Application for removal or variation of a condition following grant of
planning permission. Town and Country Planning Act 1990.
Planning (Listed Buildings and Conservation Areas) Act 1990

Proposal: Single storey rear extension.
Location: 3 Ceres Crescent, Epsom, Surrey, KT17 1FF
Application Number: 21/00629/FLH

We want to request retrospective variation of condition (2) of the decision issued on 11 Aug 2021 which states that:

DWG NO: **LIVARCH/3CC/105** ISSUE: **A**

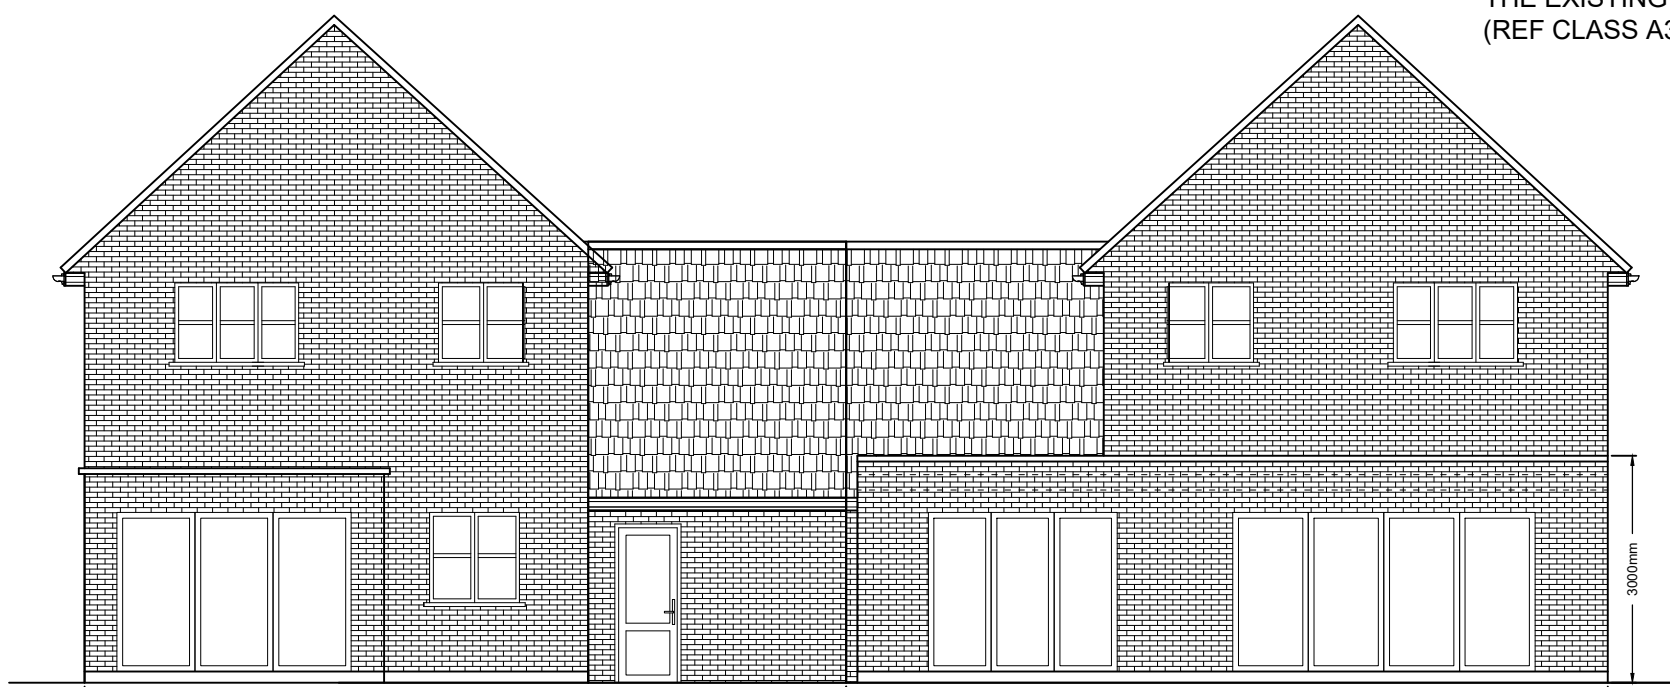
Condition 2 of the decision issued on 11 Aug 2021 is referring to plans that have an incorrect existing and proposed height measurement (2835mm) which we want to correct through this application.

The correct height is 3000mm.

We want to request variation of condition 2 of the decision issued on 11 Aug 2021 so that instead of following plans it refers to the updated plans attached with this application that contain the correct height measurement of 3000mm
